Rezoning Transportation Analysis

Petition Number: 2023-031

From: Jake Carpenter, PE

| Date | Description |
|---------|---------------------|
| 8-23-23 | Second Review (PDM) |

SHEET NUMBER
RZ-1.00

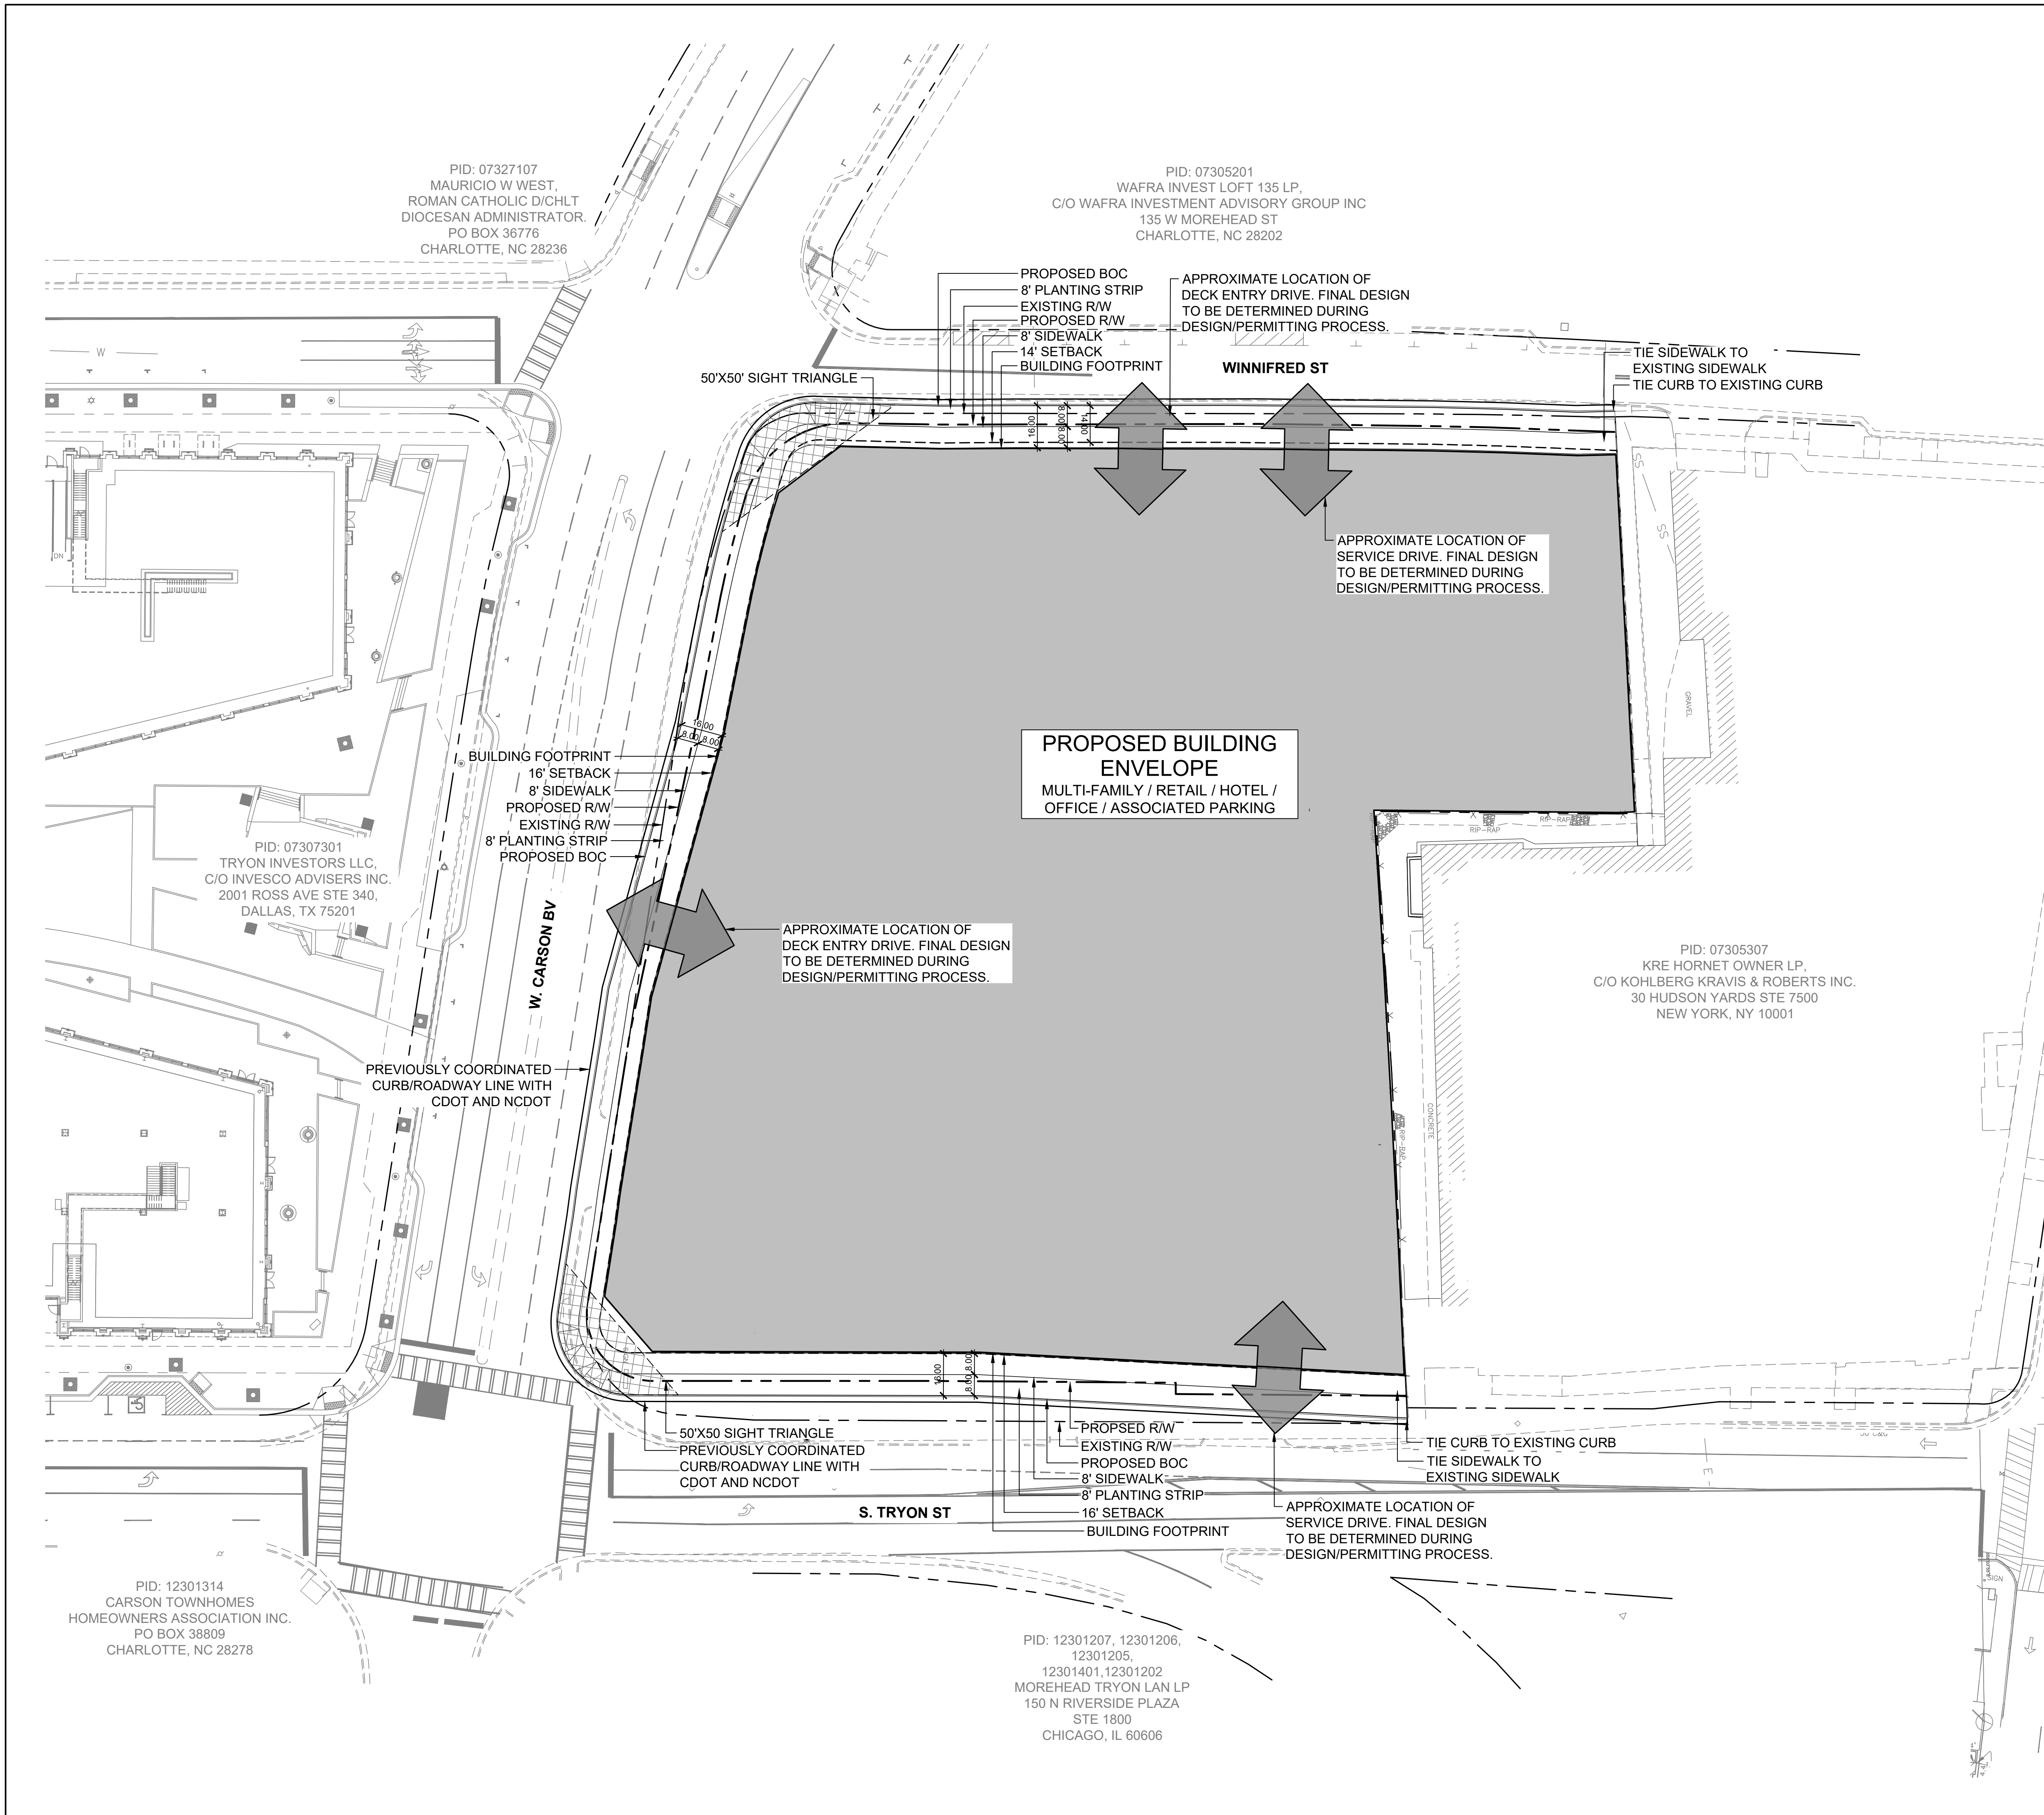
Label and dimension the curb and gutter from the centerline for each road on the site plan.

New Comment from 8.23.23: Curb lines need to be dimensioned on the site plan for each public road. Previously coordinated back of curb locations will be used.

- ~~3. Revise site plan to dimension the curb lines and right-of-way for each public road from the roadway centerline.~~
4. Revise site plan to restrict access South Tryon Street and East Carson Boulevard to right-in / right-out.
- ~~5. Revise site plan and conditional notes to show how and where the proposed maneuvering within the setback will occur. Additional comments may be provided by CDOT based on proposed maneuvering plan once more information is provided.~~
- ~~6. Revise site plan and conditional notes to provide clarity to the proposed phasing plan. Site plan should show the limits of each phase.~~
